From: Laura Gibbons
Sent: 30 August 2019 16:01
To: Planning.Responses <Planning.Responses@arun.gov.uk>
Cc: Maria Tomalova <Maria.Tomalova@arun.gov.uk>
Subject: RE: Planning Consultation on: BN/66/19/PL

Engineers Comments Regarding Surface Water Drainage

APPLICATION NO: BN/66/19/PL

Site Address: Land off Canal Mews Barnham PO22 0AB

APPENDIX 5 – Sewage Treatment Plant Details

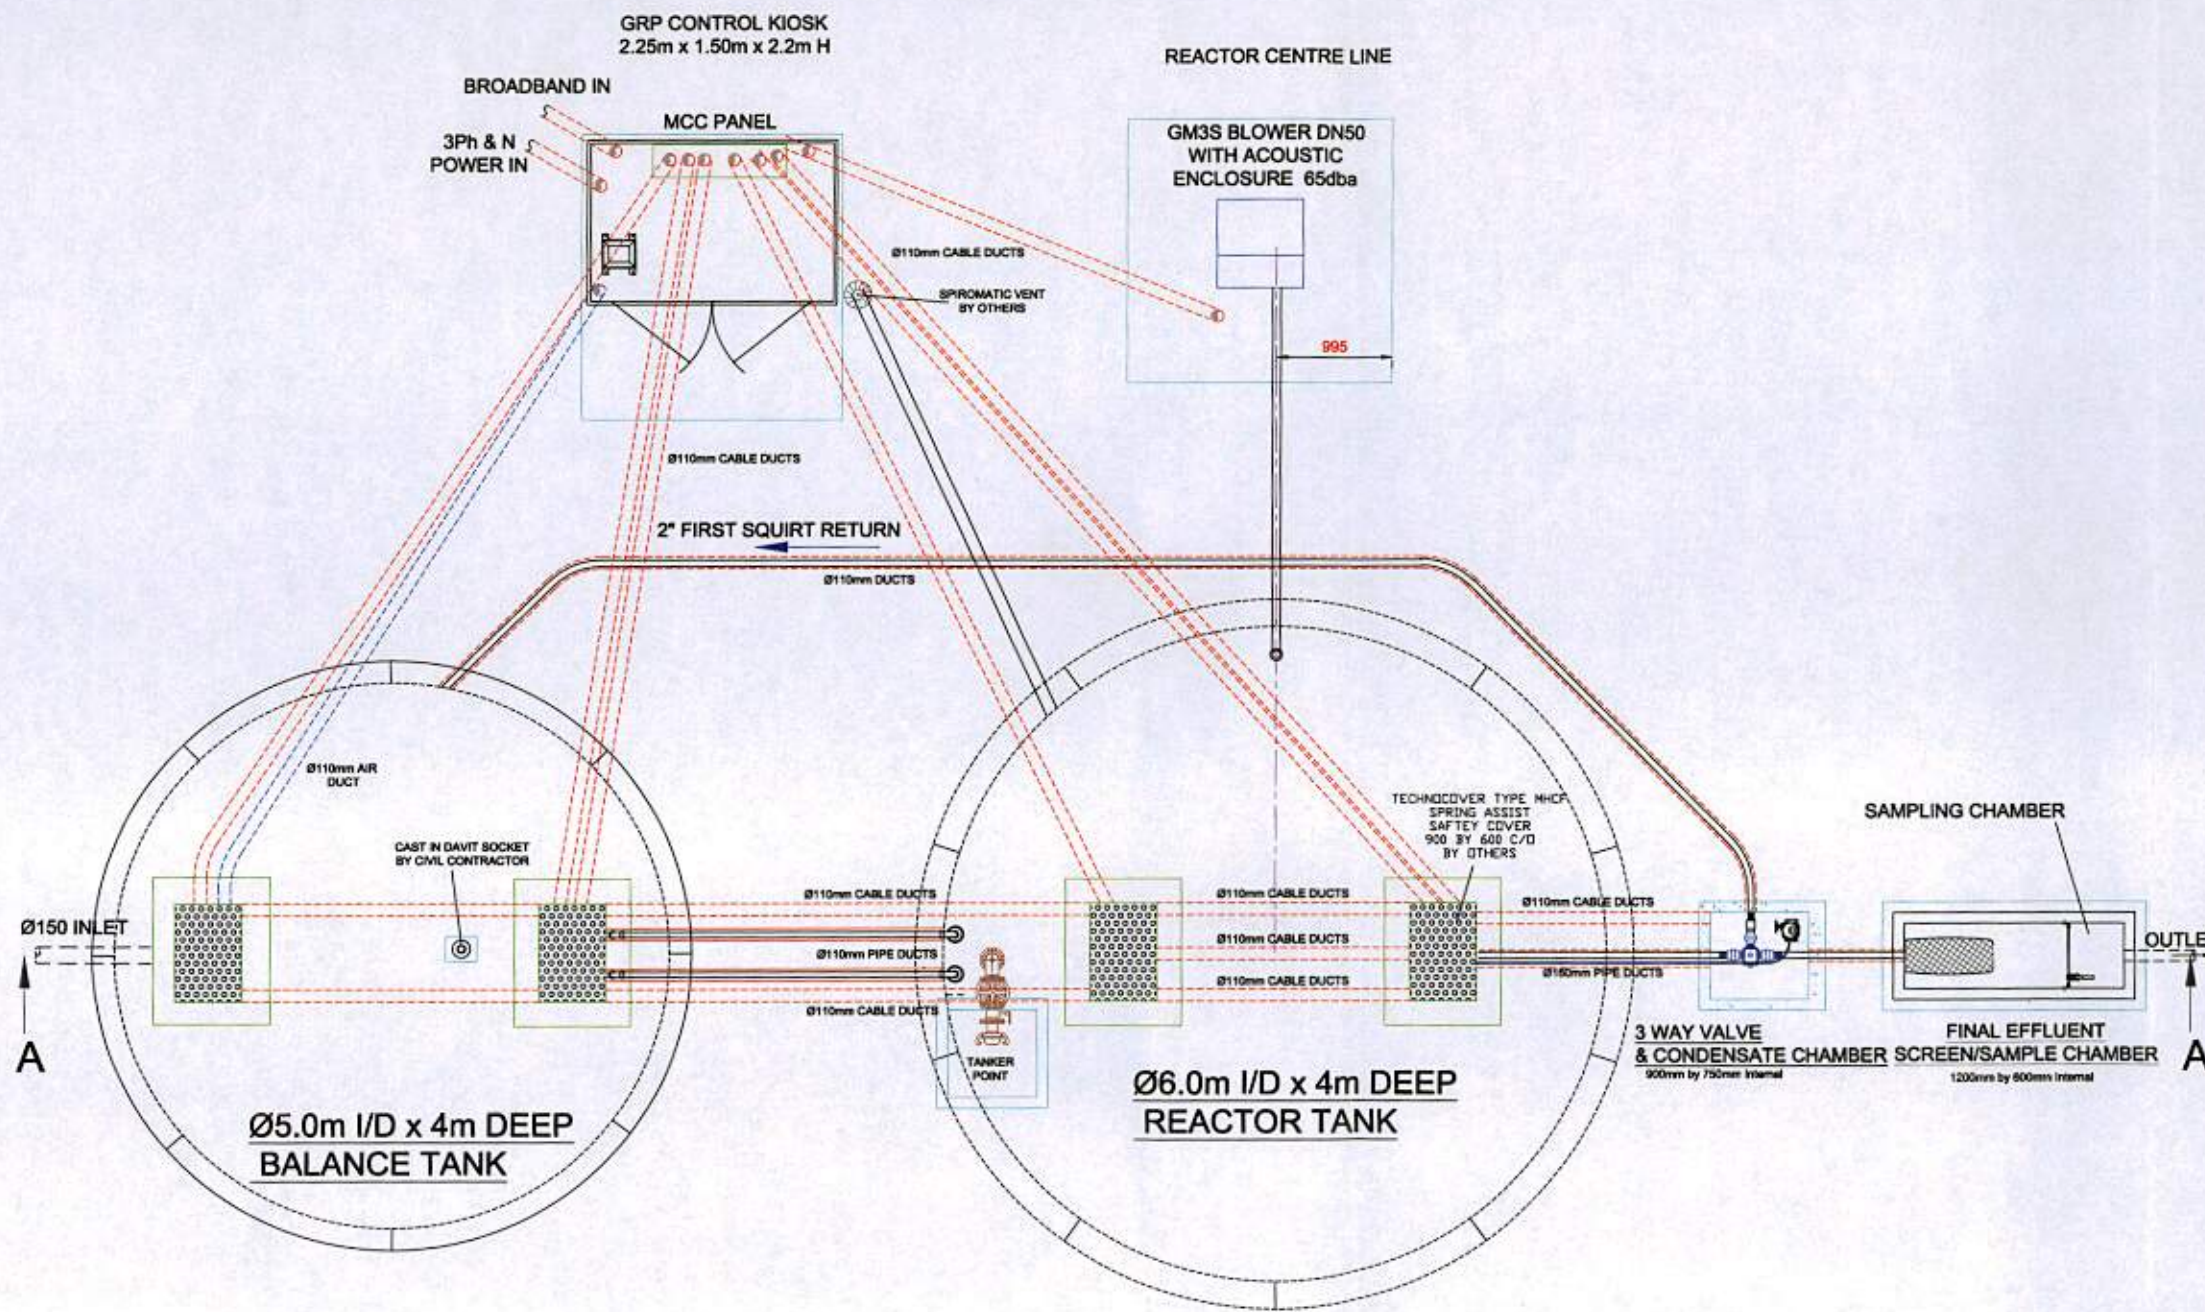
It appears that the documents submitted in support of a discharge of conditions application (reference BN/25/14/DOC) for the wider site indicate that a foul water treatment plant is located in the area of the proposed development. Please can the applicant confirm if this is the case or not. Until such time as this confirmation is provided we object to the application.
